**Re: Sevano Place Subdivision Drainage report and Grading Plan
Grading and Drainage Plan
Engineer's Stamp Date 7-18-14 (C18D075)**

Based upon the information provided in your submittal received 6-20-14, the above referenced report and plan cannot be approved for Preliminary Plat action by the DRB until the following comments are addressed:

CITY PROJECT No.	ZONE MAP NO. C-18-7	SHEET 1 OF 2
------------------	-------------------------------	----------------------------

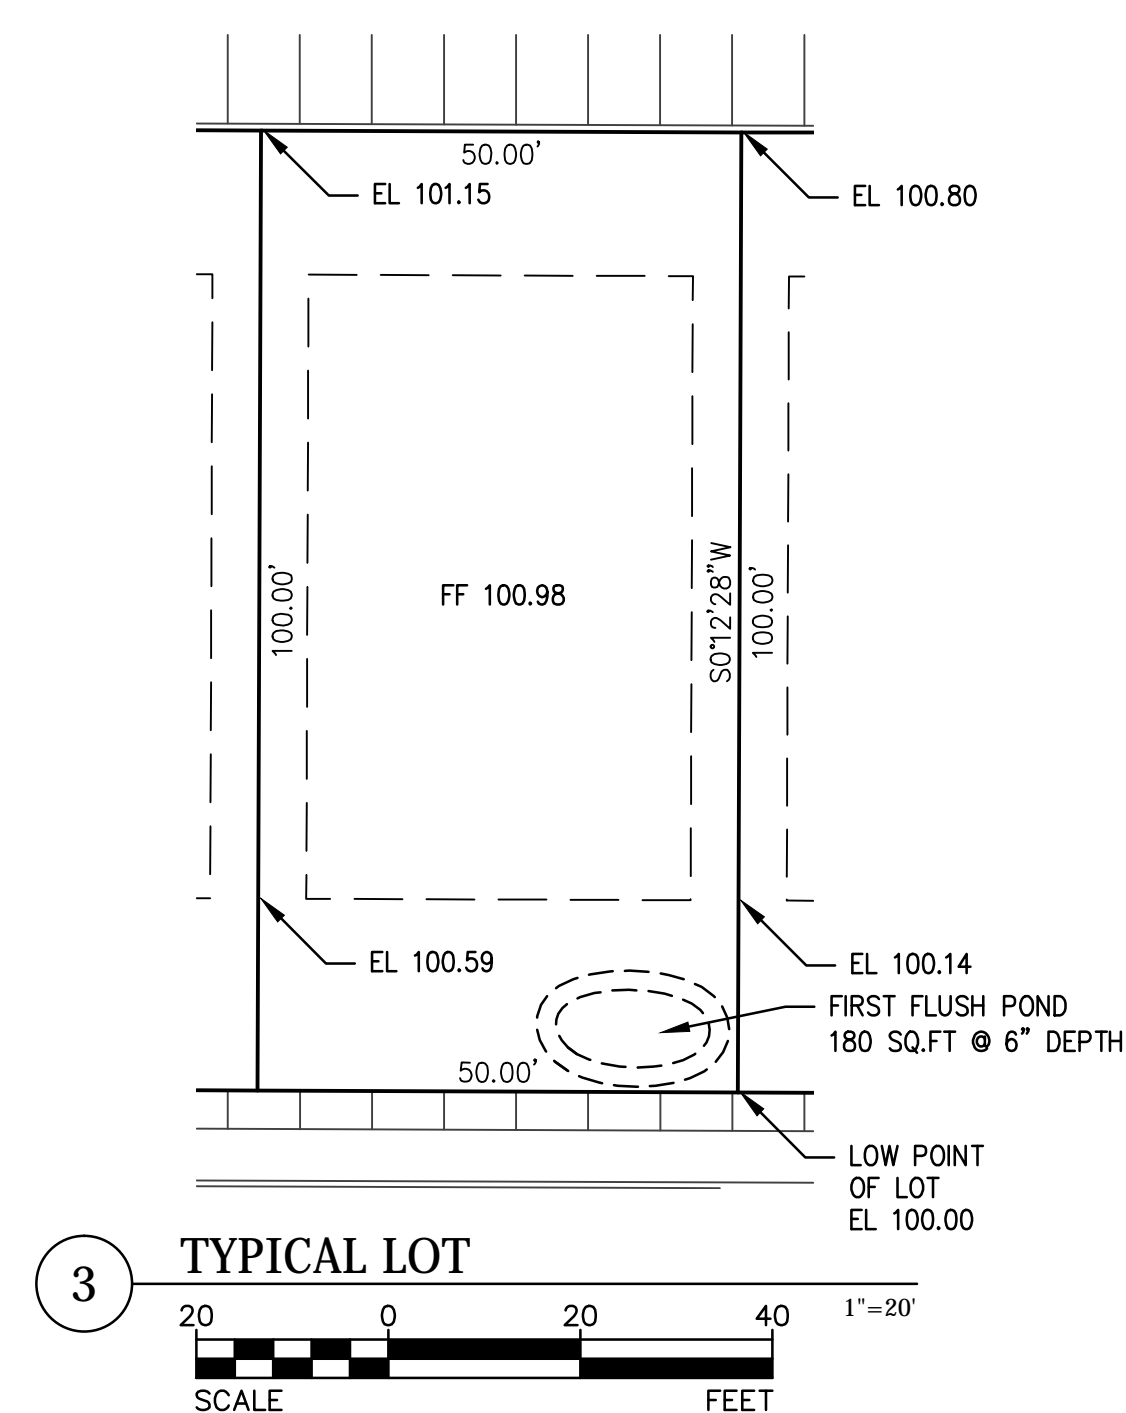
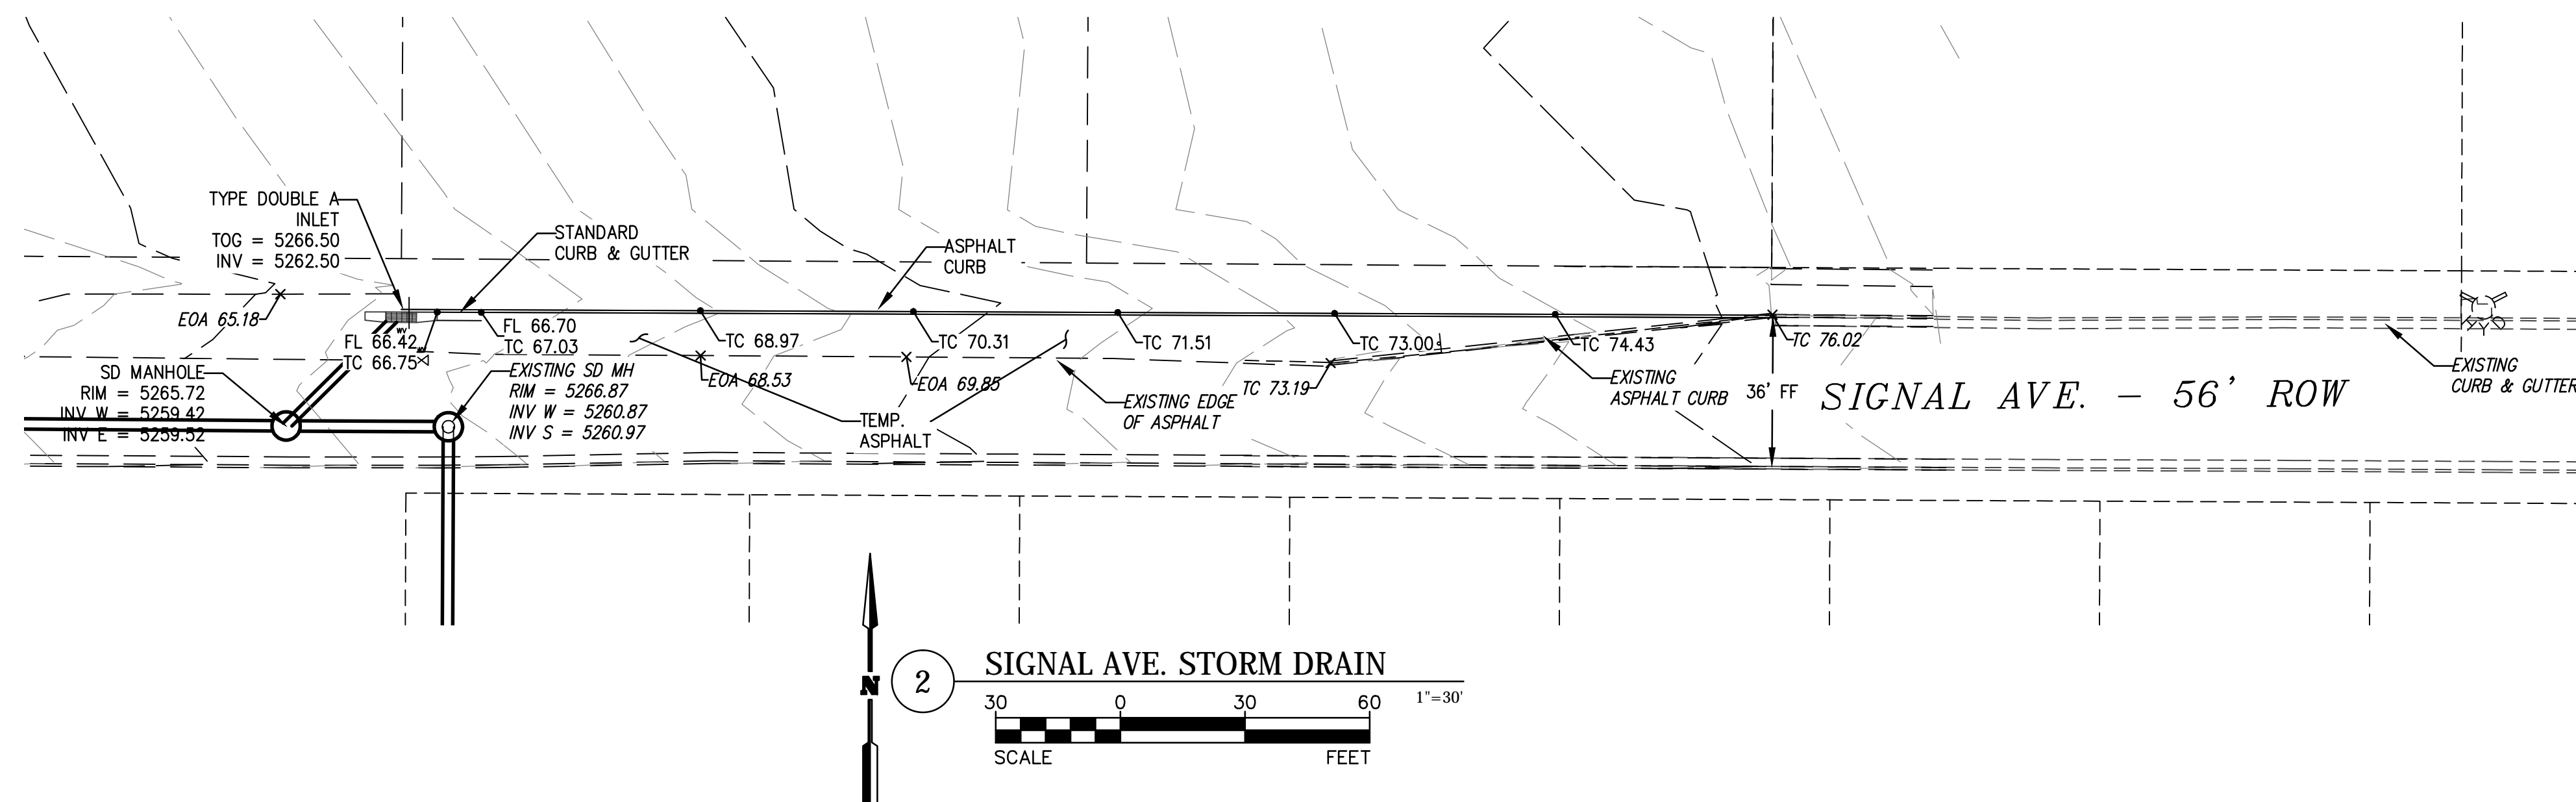
3. Show temporary asphalt on the grading plan sheet 2 of 2 in between the existing edge of asphalt and the new curb.
4. Previous-A retaining wall should be proposed on the north side of Lot 18.

Revised- Isn't a retaining wall required on the northeast corner of Lot 18? The wall line type is not continuous in this area.

6. The street slopes were omitted on this plan.
7. Basin 117.311 was run in AHYMO with incorrect land treatment. They should be 70% D and 30% B.
8. Revise the table on p. 4 to show basins 117.314 and 117.312 are 90% D 10% C as they are streets.
9. Planning and Transportation provided comments at DRB today. They should be accommodated in the next submittal.
